Blacktown
City Council

9 June 2020

SSD 9667 - Light Horse Interchange Business Hub, Eastern Creek

Attachment A - Blacktown Council's submission to SSD 9667 - Light Horse Interchange Business Hub, Eastern Creek

Drawing Name: **Landscape Plan**
PRELIMINARY
Scale: 1:500 @ A1
Job Number: **SS18-3892**
Drawing Number: **101**
Issue: **G**

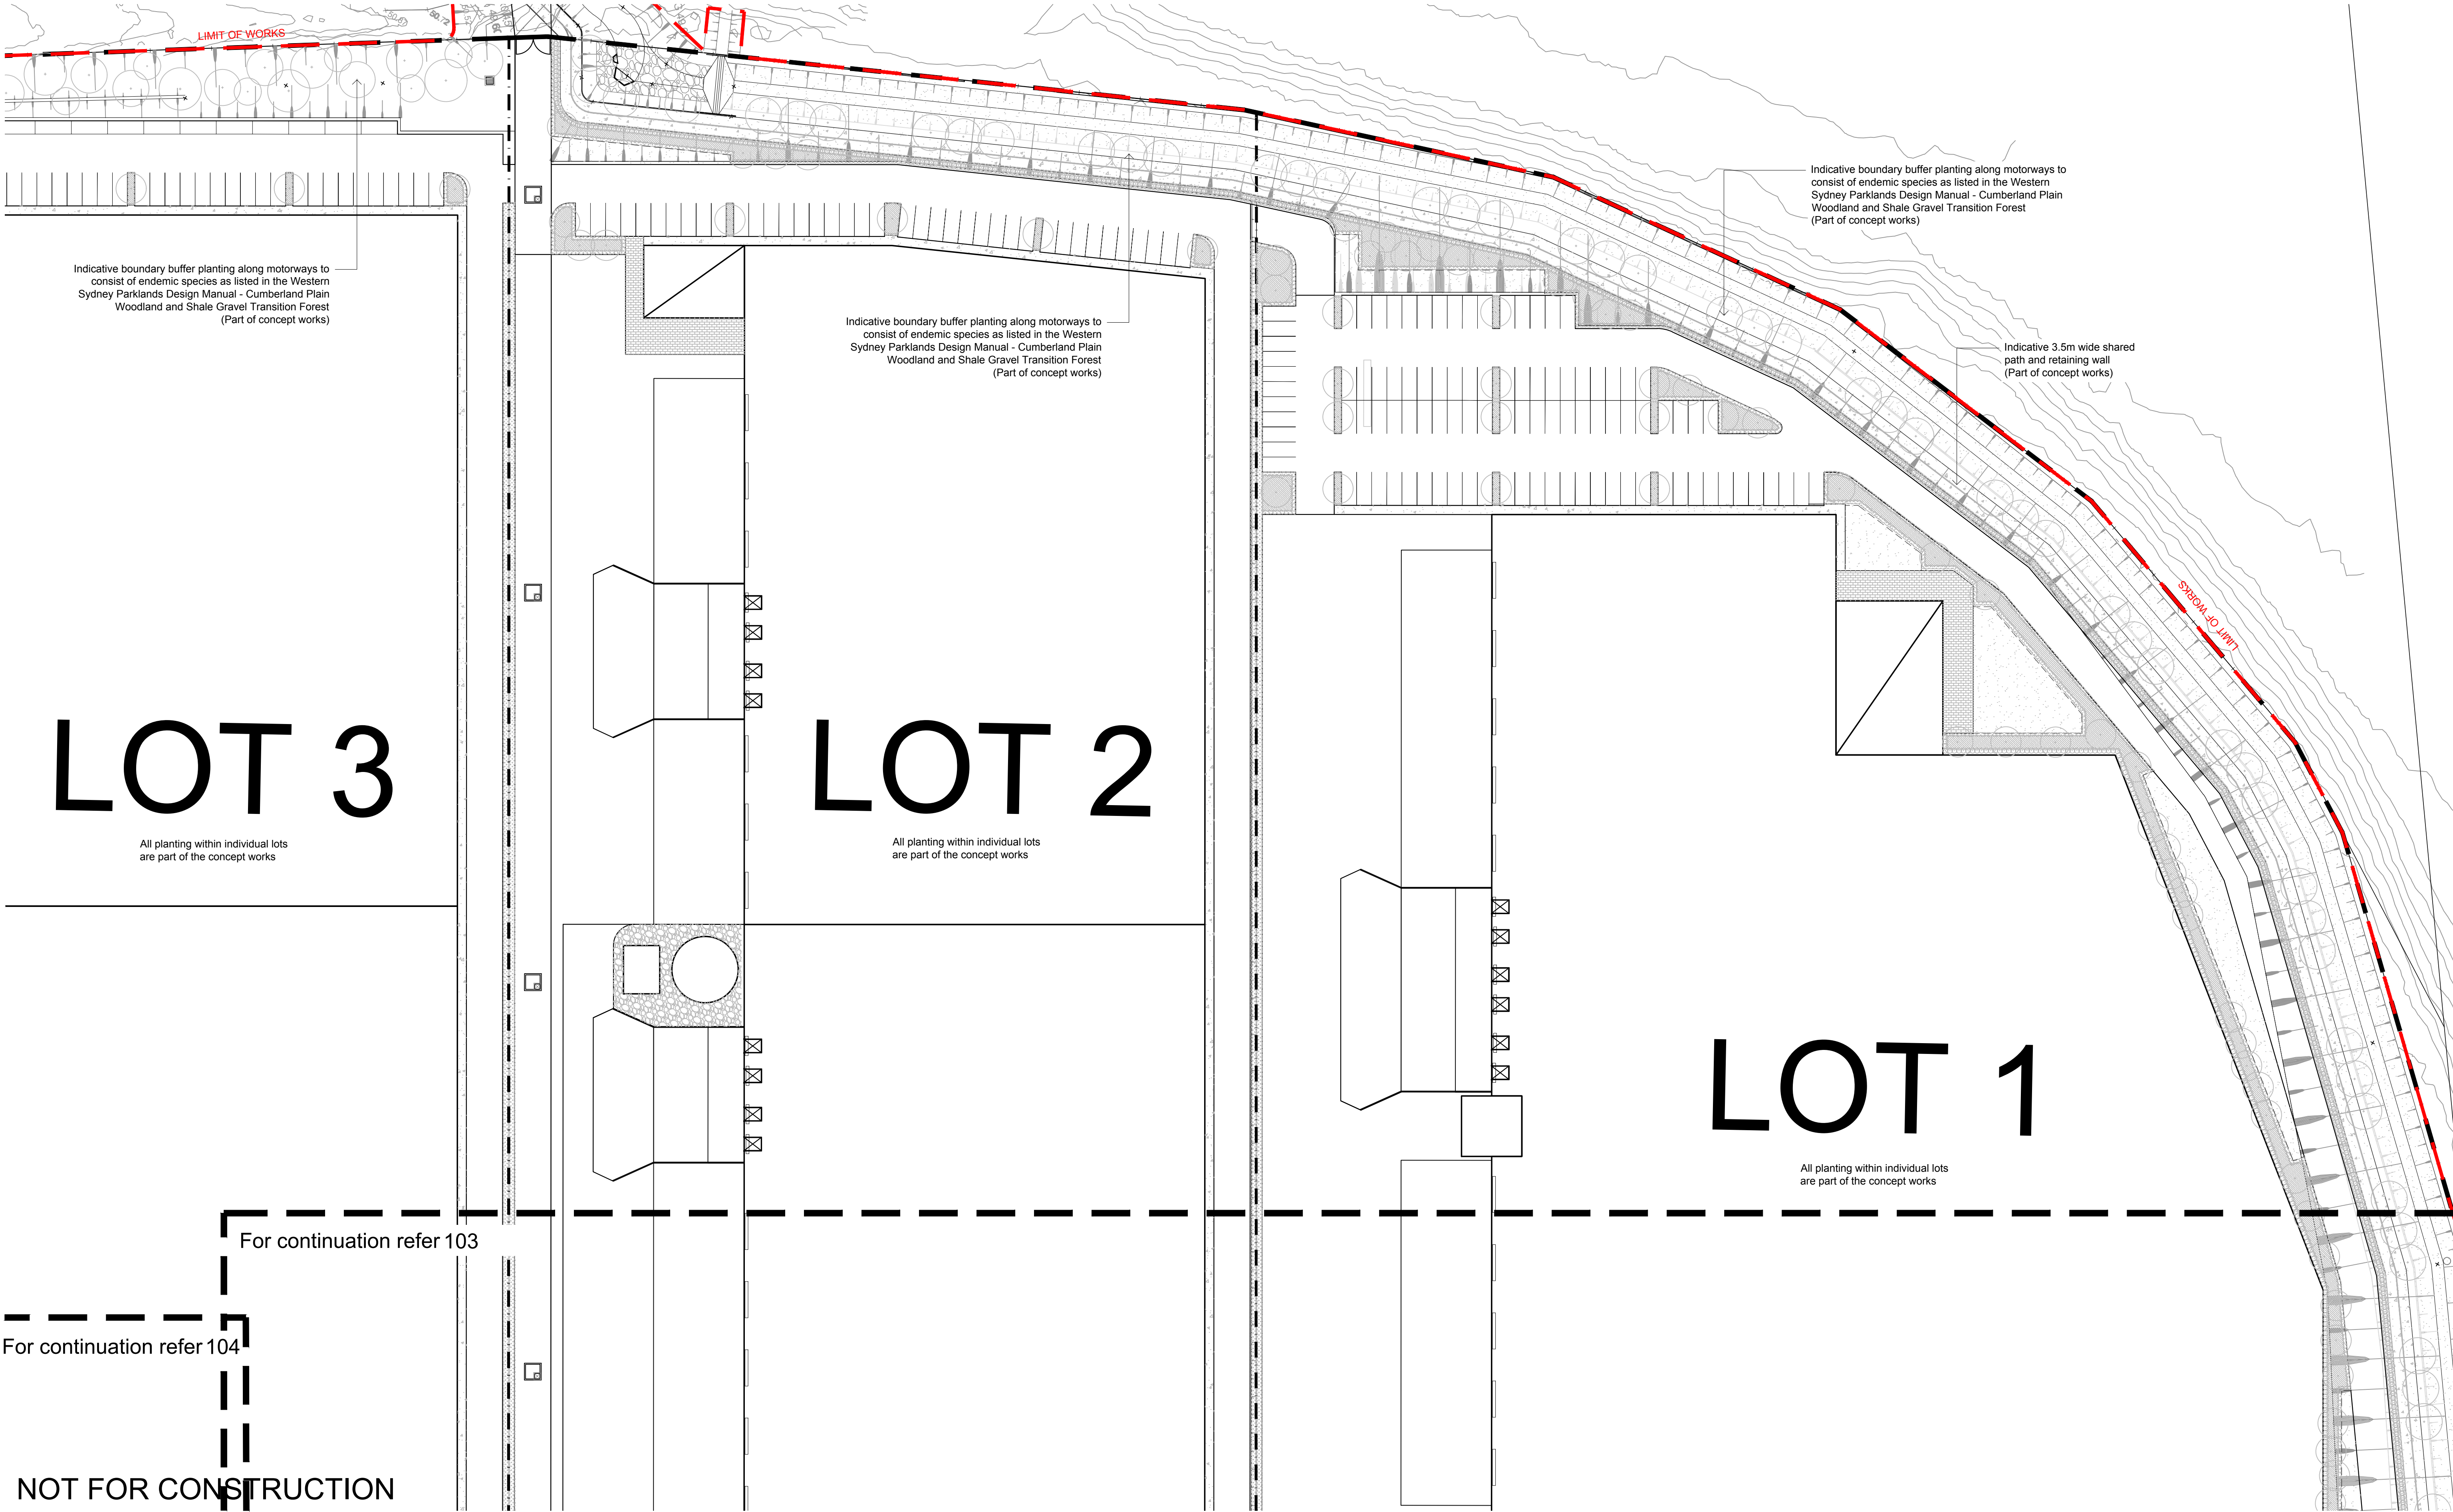
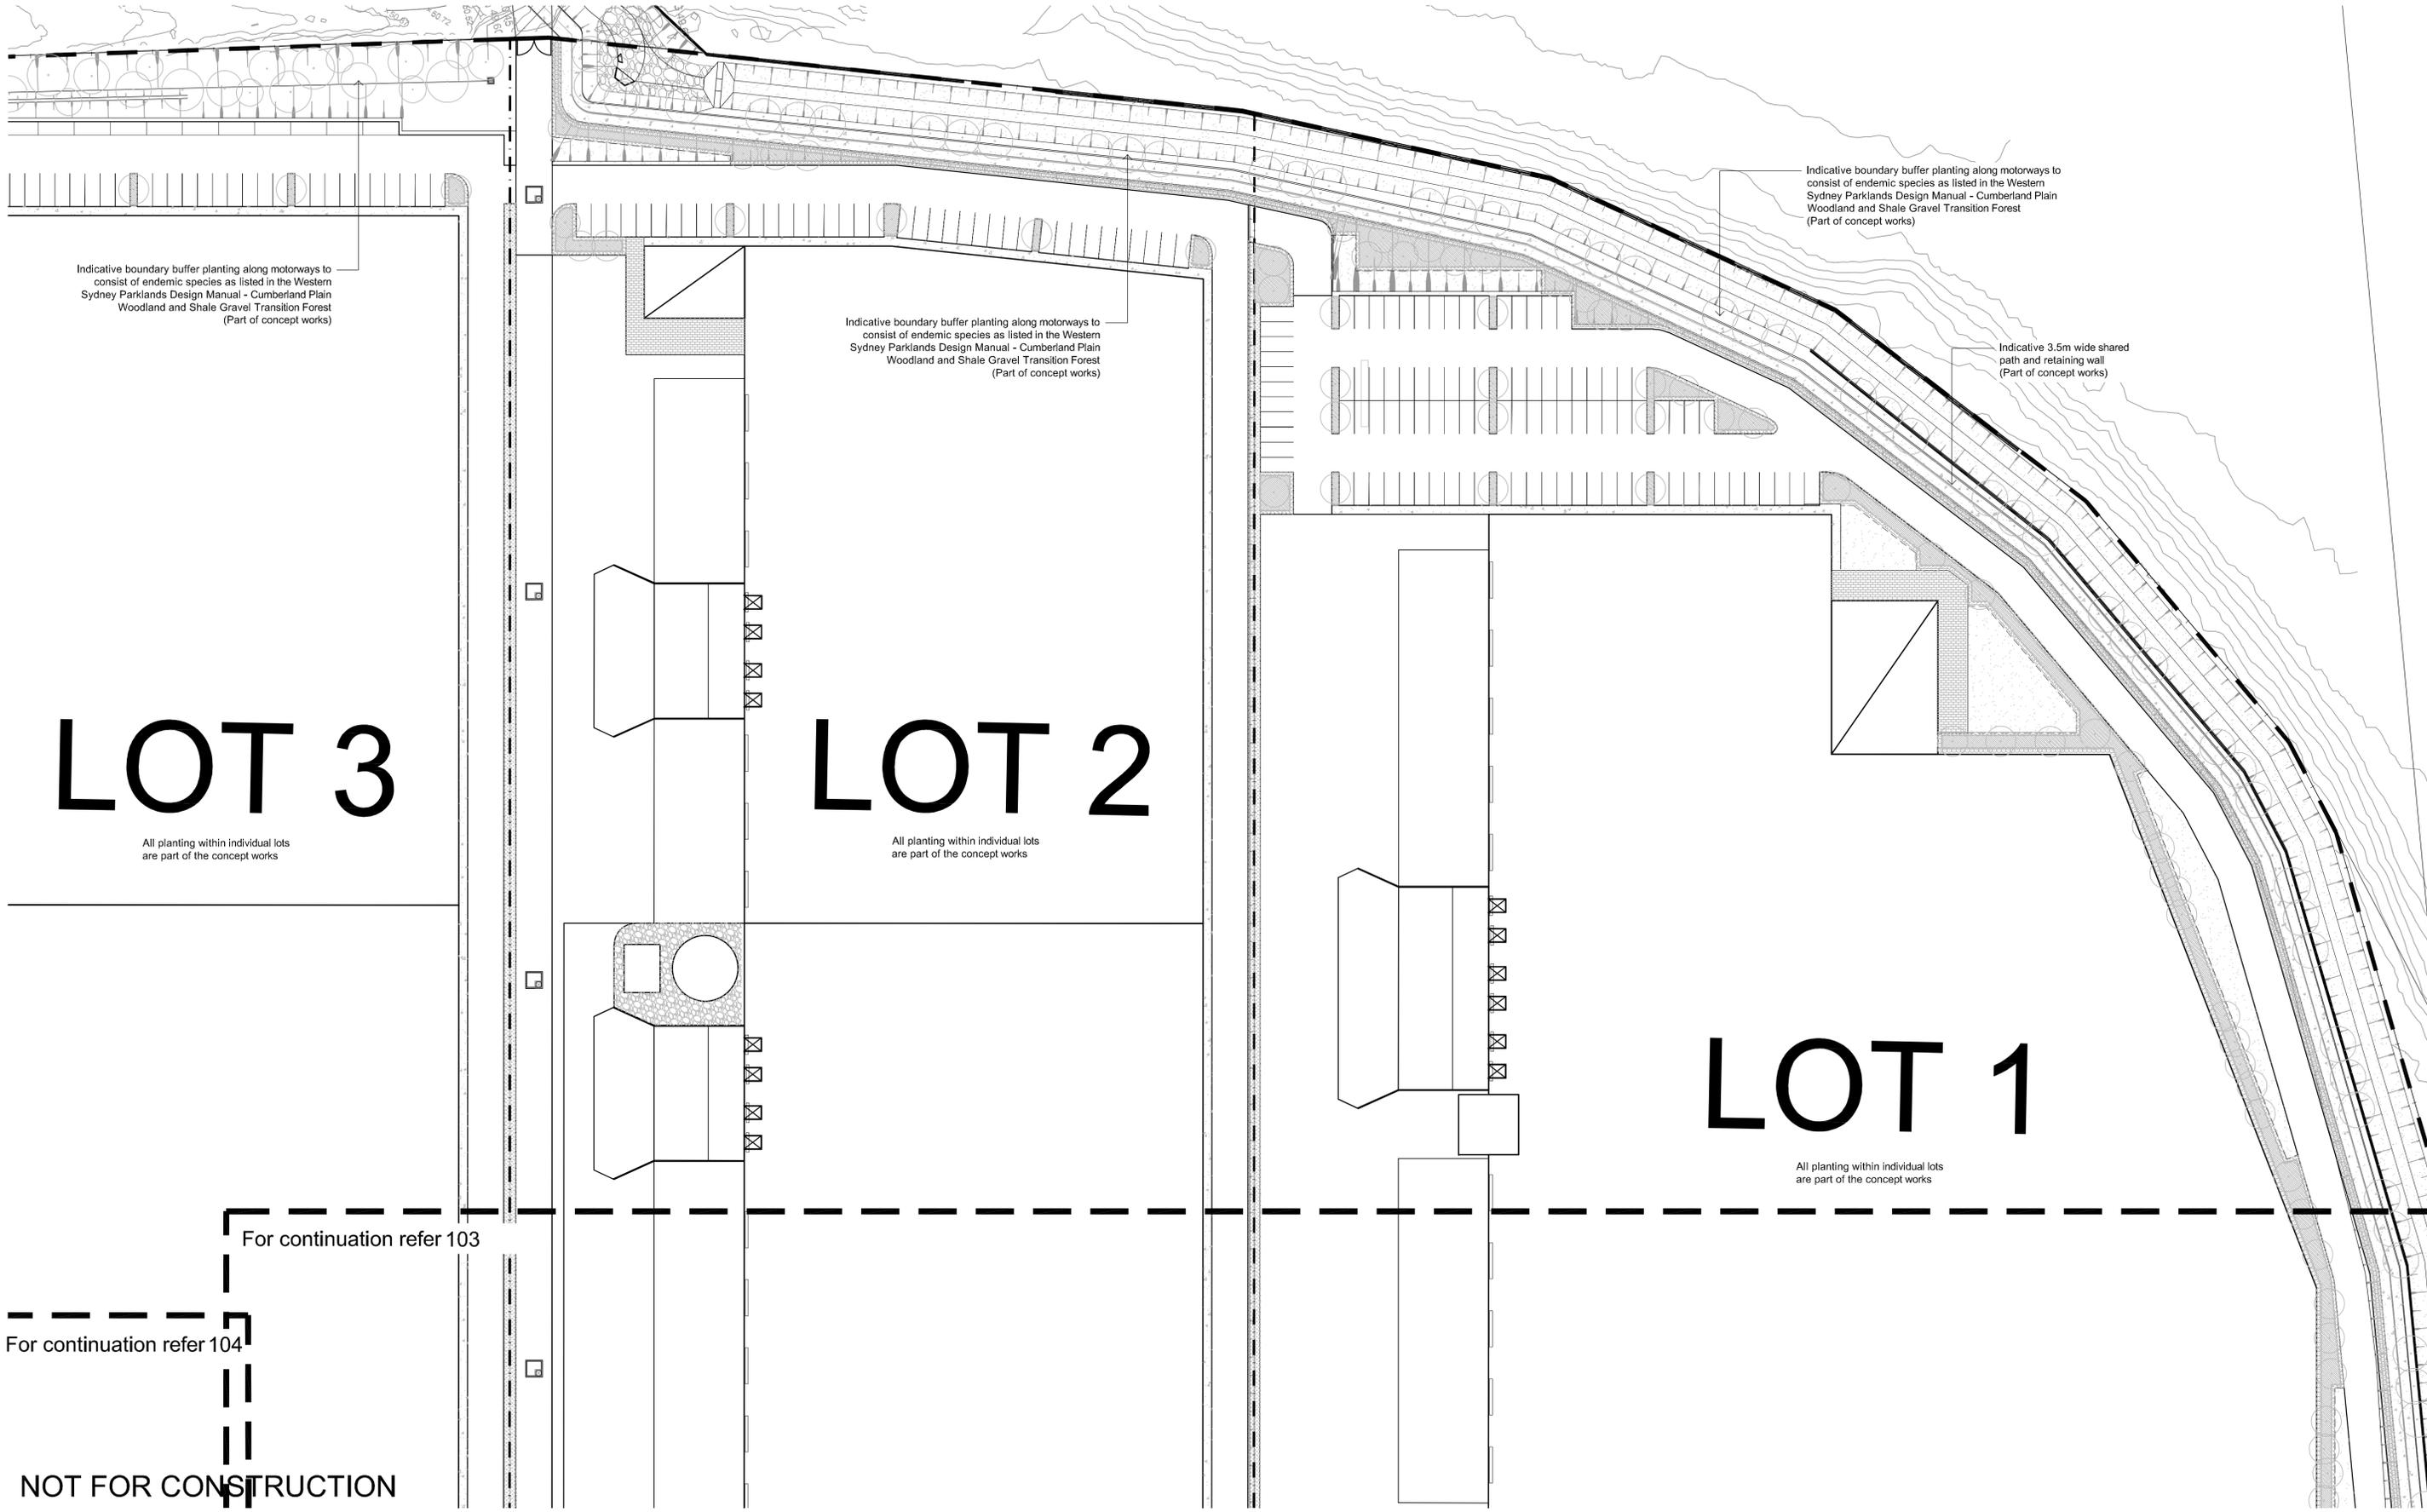
6. Provide revised landscape plans by Site Image Job number SS18-3892 dated 7/05/2020 to address the following:
 - a. Extend the landscape works to the full extent of the riparian protection zone for the relocated Eskdale Creek up to and including the confluence with Reedy Creek. The vegetation is to be generally in accordance with the Biodiversity Development Assessment Report (BDAR) prepared by Eco Planning 2019.

- b. Show landscaping over all the fill batters using densely planted local native provenance within Lot 9 and Pt Lot 10. The fill batters supporting Lots 6 and 8 are to include substantial tree species to compliment the riparian corridor and screen the future development.
